**Proposed Residential Development, 36 Units of Sheltered Accommodation
McCarthy and Stone; 262 Hawthorn Road, Bognor Regis**

Proposed development of 262 Hawthorn Road with 36 units of sheltered accommodation by McCarthy and Stone.

Proposed development of 262 Hawthorn Road with 36 units of sheltered accommodation by McCarthy & Stone

**SITE PLAN &  
O/S MAP**

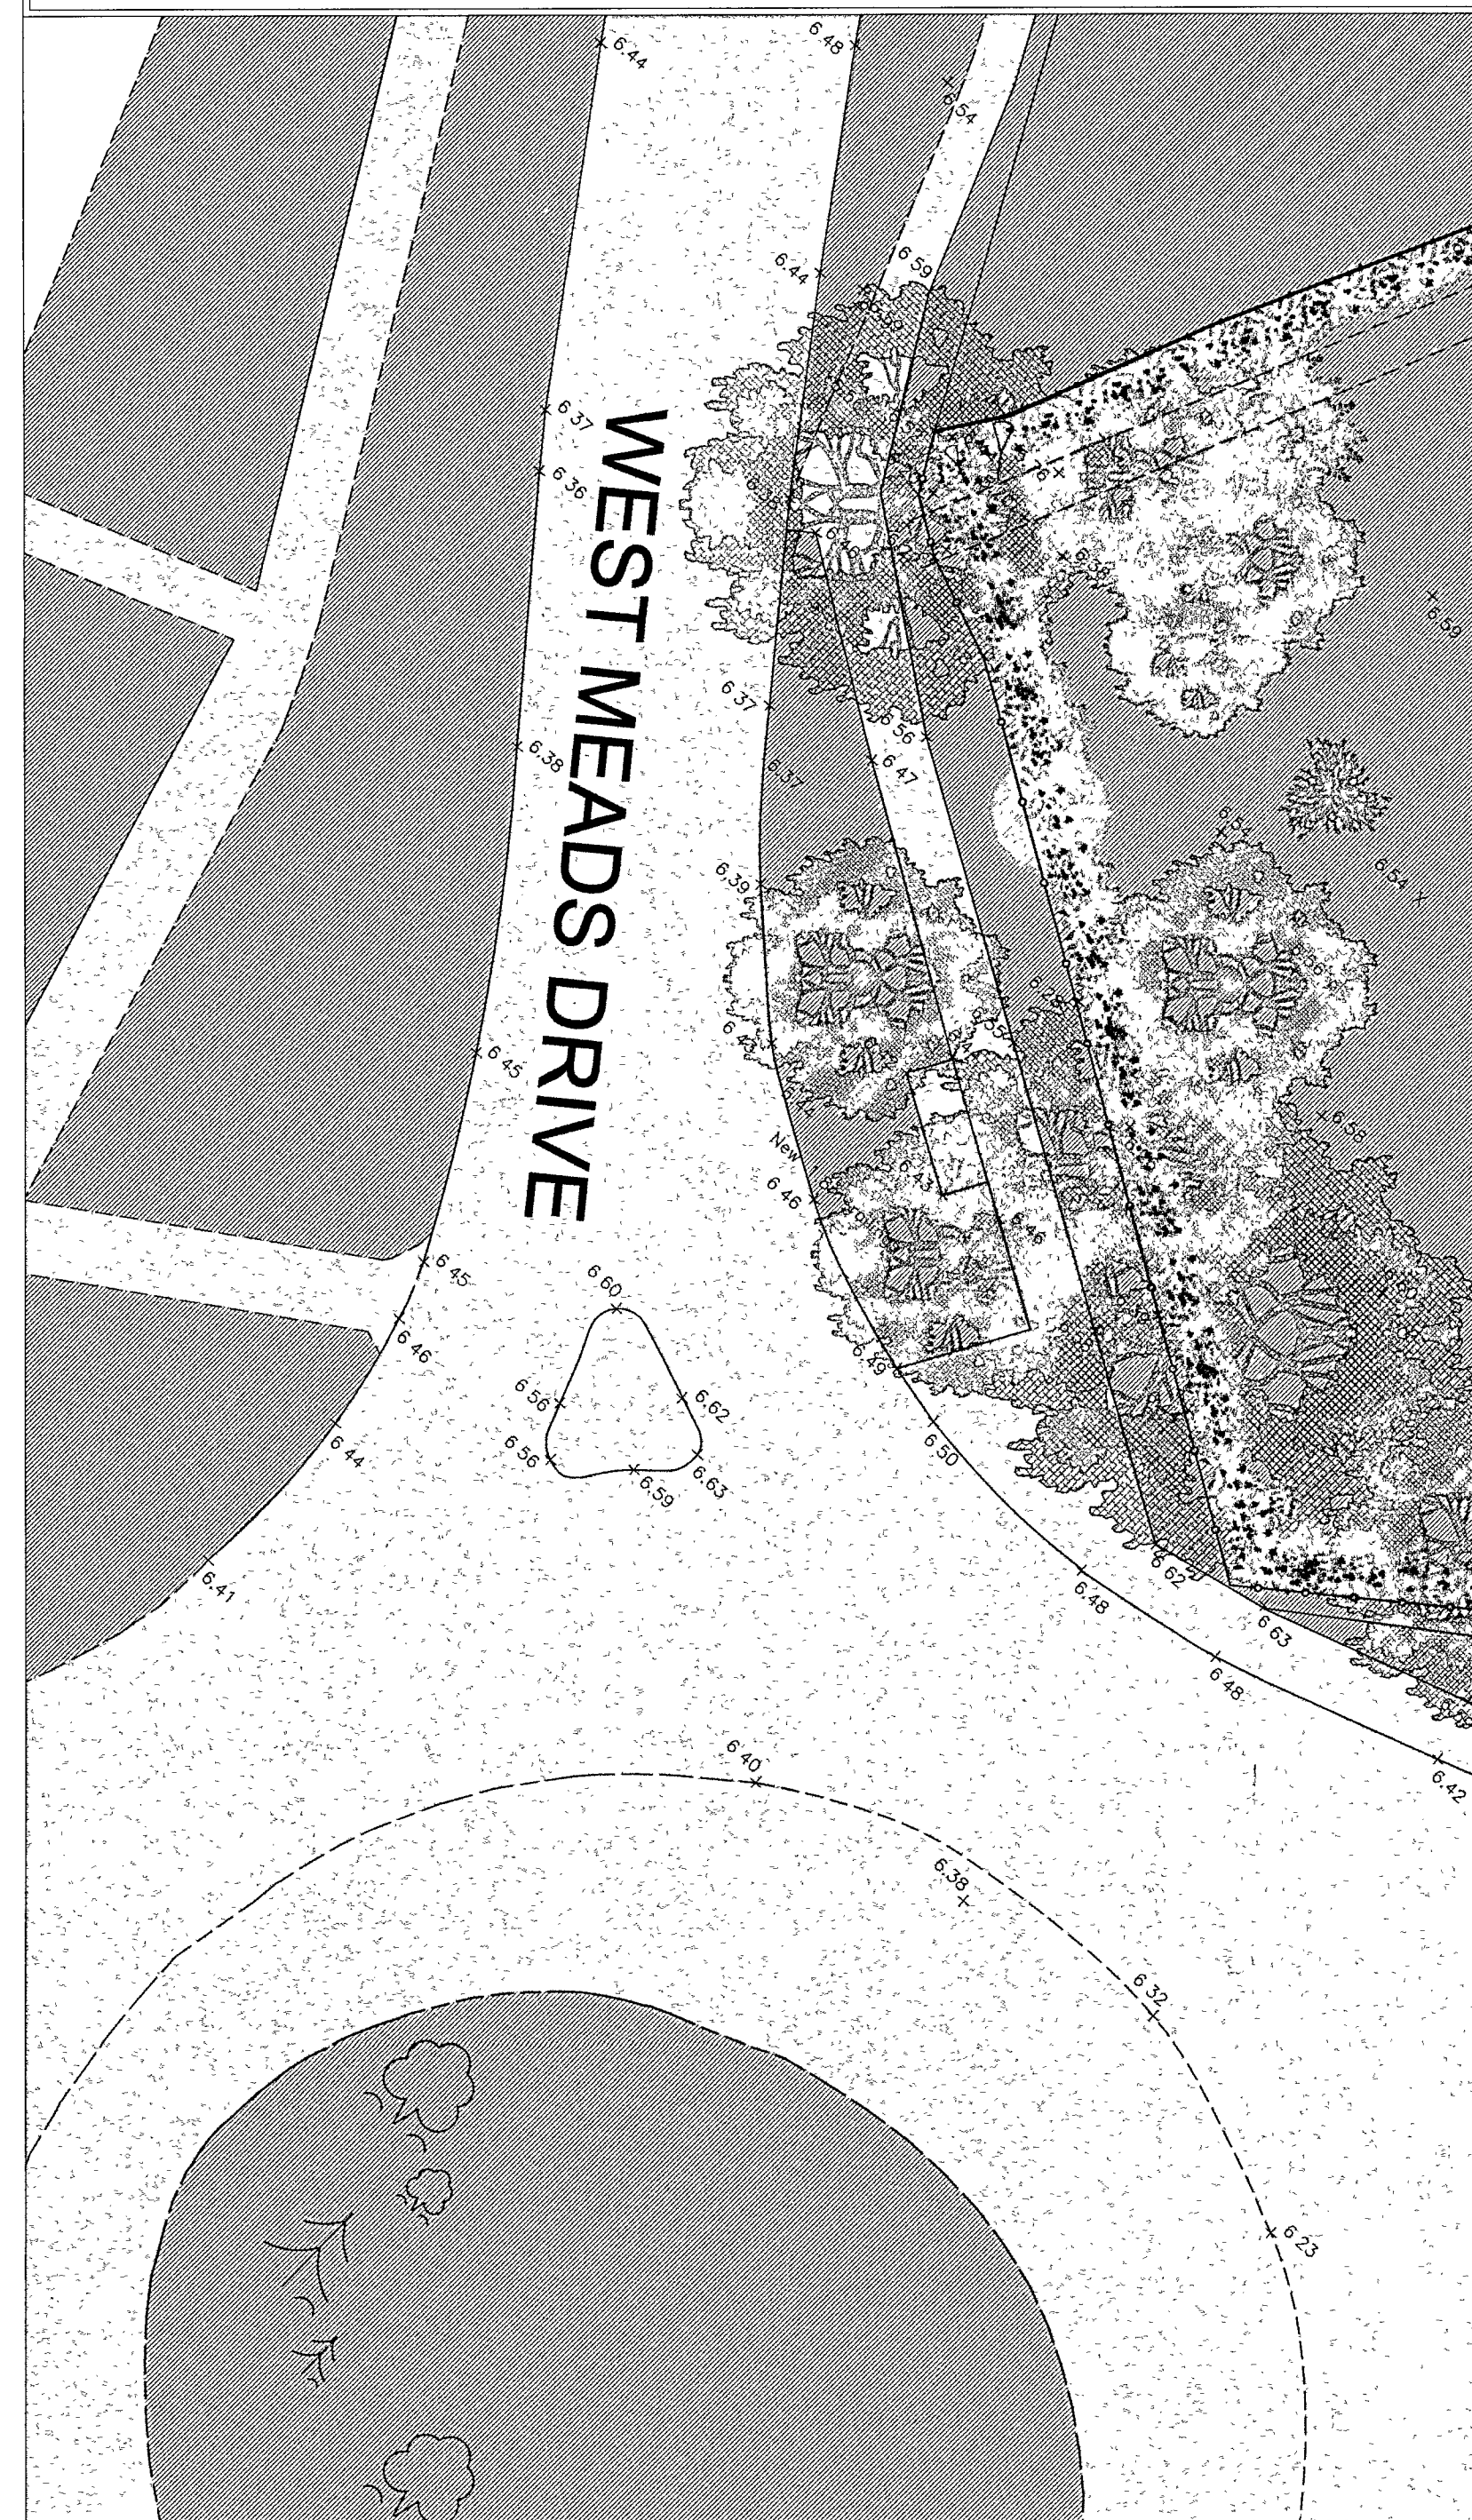
The frontage of the building has been moved back only marginally from the Hawthorn Road boundary by between 1.5 m at the critical S corner and 4.1 m at the less important NE end but is in fact closer to boundary at a point near the centre of this elevation by 1m.

The position of the important and visually dominating corner fronting the roundabout is essentially unchanged.

The SW elevation has been moved back from West Meads Drive by between 3.3m and 5.2m.

The windows in the NE elevation directly overlooking the garden and patio of 252 are 3 living room windows, 3 bedroom windows and a kitchen window. The distance of the NE elevation of the new proposal to the separating boundary has only been increased by 2.3m at the least. This can by no stretch of the imagination resolve this issue. In addition the building has now been extended to the N parallel to the boundary of 252 by a further 3.4 m.

The extending of the NE return wing by 3.4m to the N has now raised the question of loss of privacy for numbers 14 and 16 Newhall Close. The N elevation of the return wing of the proposal has a living room and 2 bedroom windows at first floor level. These windows directly overlook the garden and amenity areas of numbers 14 and 16 Newhall Close. This N elevation is only 17.7m from the rear wall of no 14 and only 20.3m from the rear wall of no16.

The 2m wide footpath indicated on the layout plan and annotated as follows "New 2m wide footpath to be provided to link with existing to east" presumably forms part of the application.

The land required to form such a footpath is neither owned nor controlled by the applicant. It is within the registered title of the various frontagers of this part of Hawthorn road. I therefore believe it is absolutely necessary that the owner of 252 and the adjoining owners are properly served with the appropriate certificates. It would be entirely wrong that land that has been maintained, tended and planted for many many years by the owners and is within their registered titles could potentially be suddenly and without warning dug up and tarmaced over without them receiving any formal notice.
